CITY OF MERCER ISLAND

Pre-Application Meeting (PRE18-061)

Site Location: 2825W Mercer Way, Mercer WA 98040

Brief Project Description: Proposed 14-lot residential long subdivision

PRELIMINARY UTILITY PLAN
2825 W MERCER WAY
 PRELIMINARY PLAT
 PARCEL #2174502425
 CITY OF MERCER ISLAND WASHINGTON

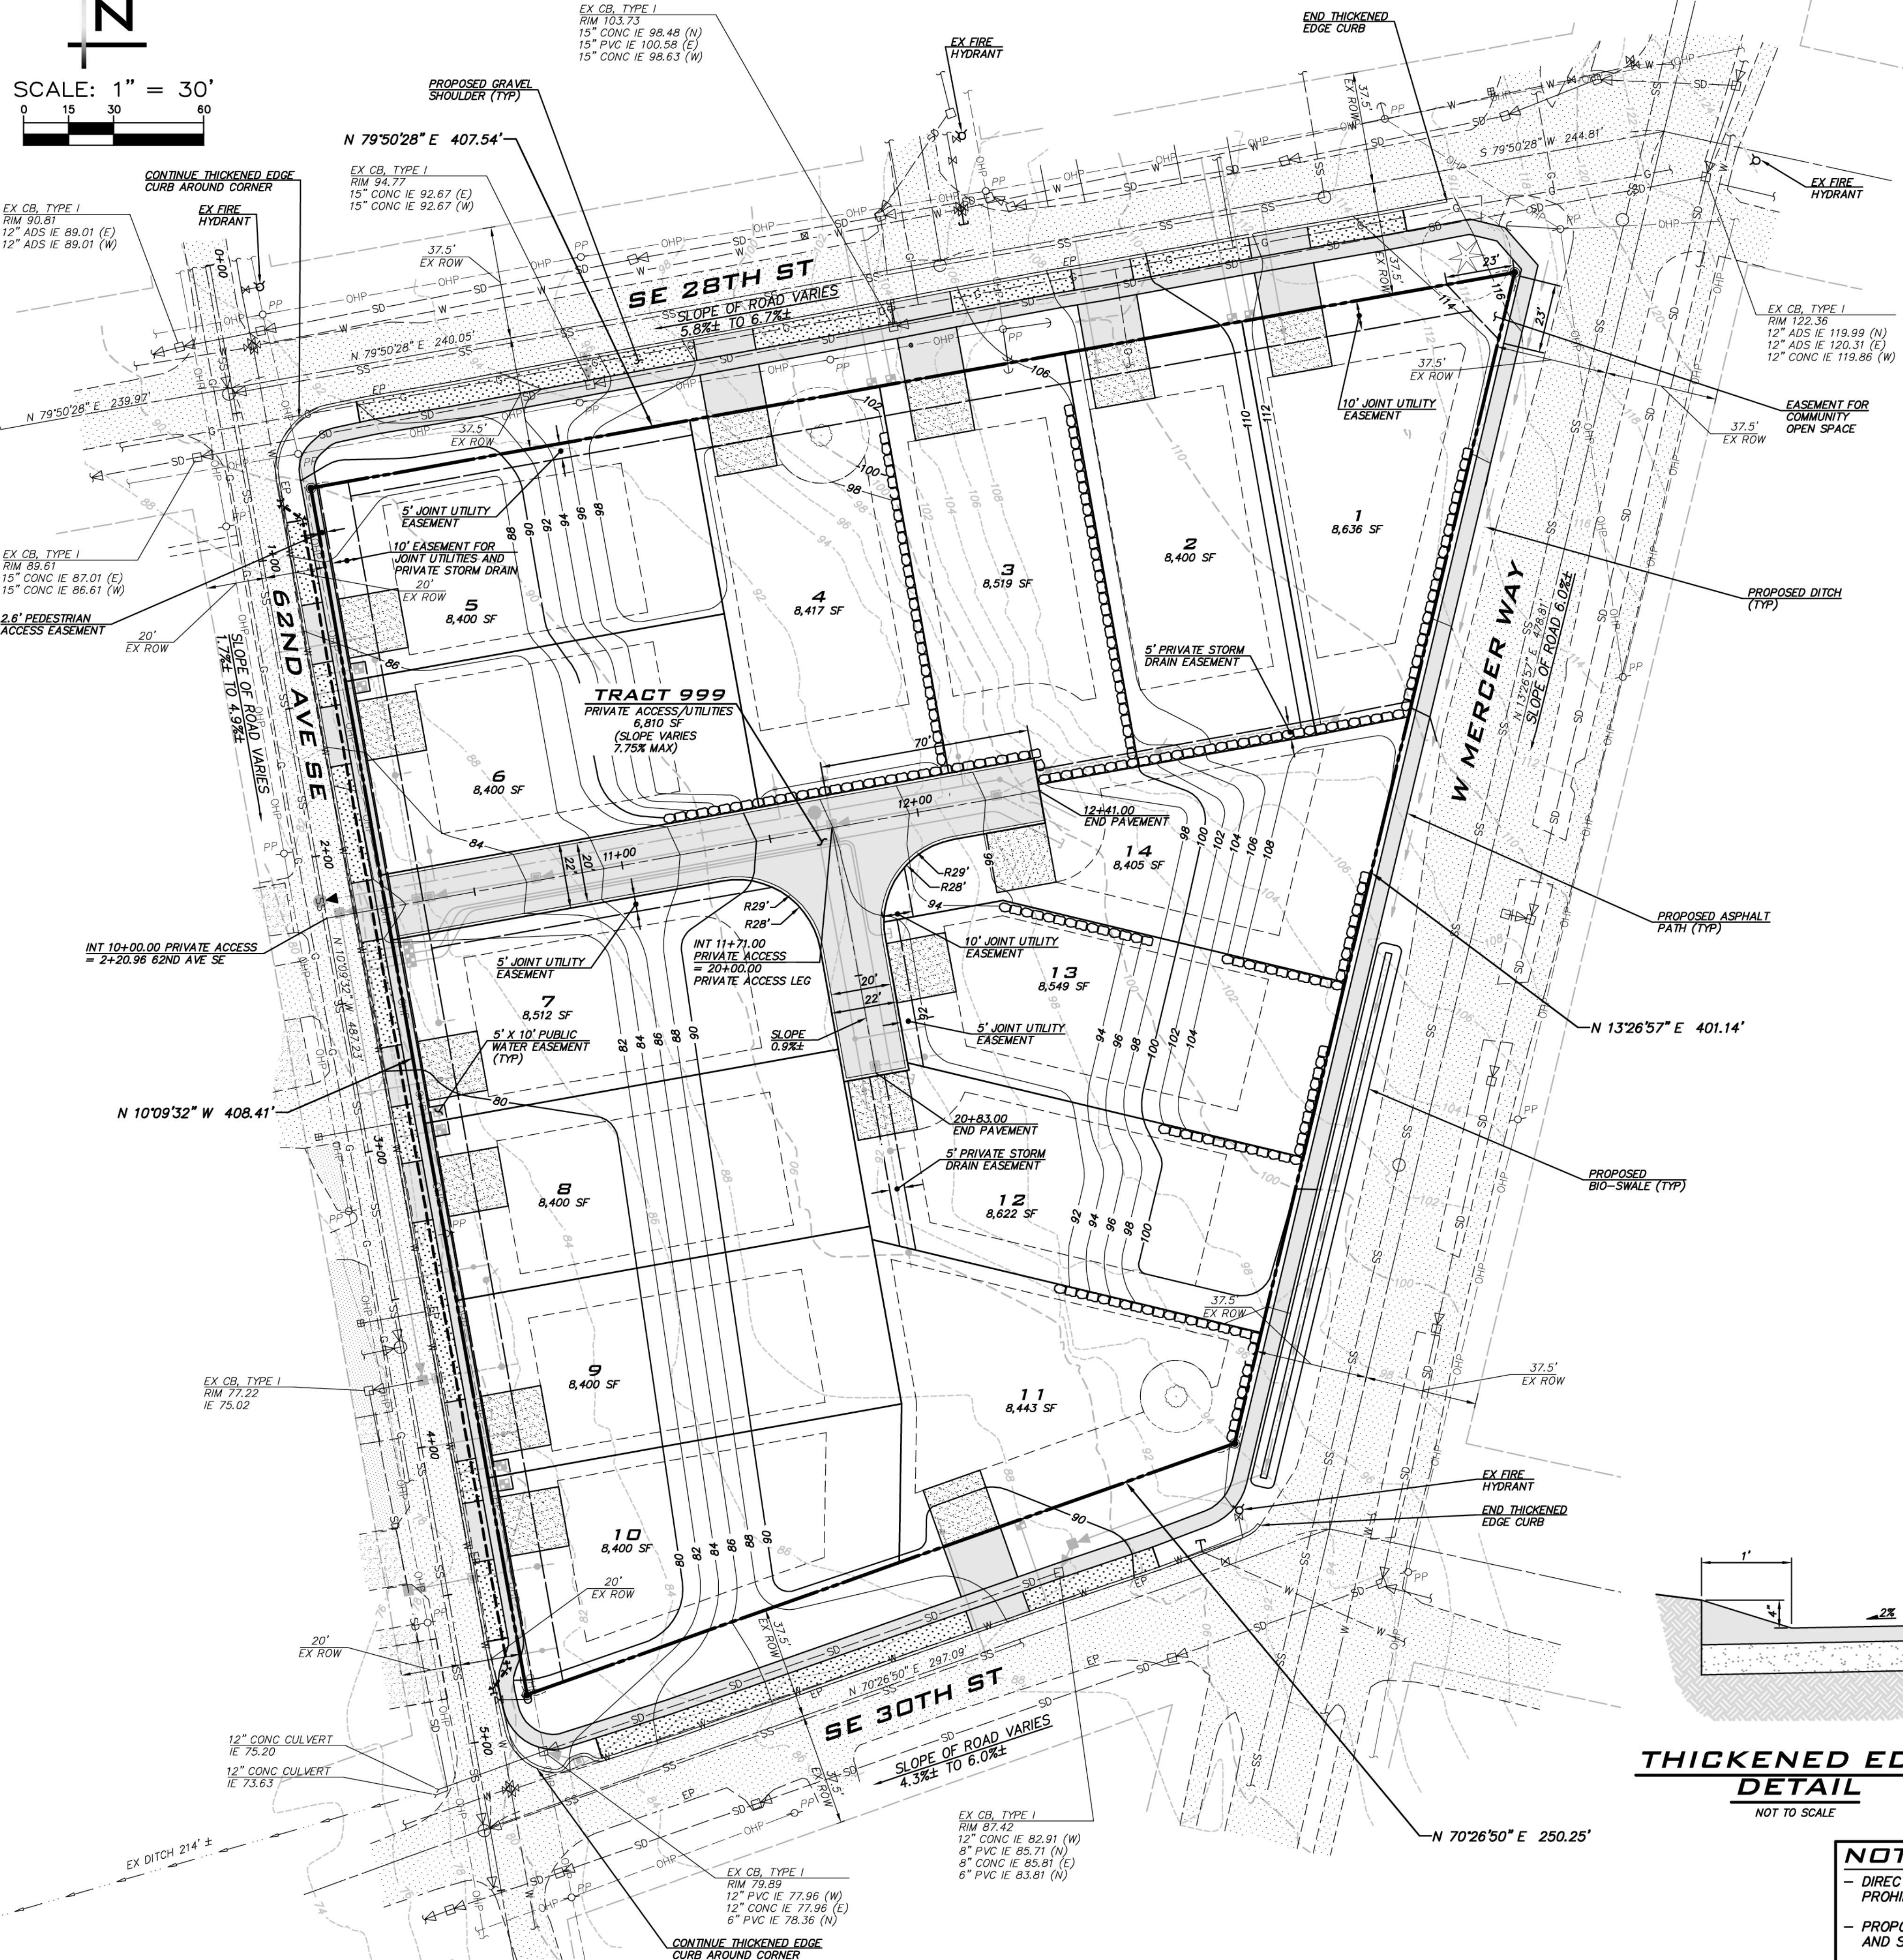
7. *There is an existing water main that runs through the middle of the site. We would propose to remove it as part of this project. Please confirm that is acceptable.*

6. Confirm there is adequate water and sewer service for this property.
 - Yes
7. There is an existing water main that runs through the middle of the site. We would propose to

remove it as part of this project. Please confirm that is acceptable.

-No. Keep the main and widen the existing easement to 25' centered on the actual location of the main. Alternatively, we will consider allowing the abandonment of the main and extinguishment of the public water easement if sufficient mitigation is provided through water system improvements that provide a reasonable public benefit.

-The City Council must approve extinguishment of the water easement if the main is allowed to be abandoned. The City Council will want to understand the benefit received by the City for the abandonment.

-Verify with the Fire Marshal that abandonment of the water main will not result in additional fire protection measures including fire hydrants.
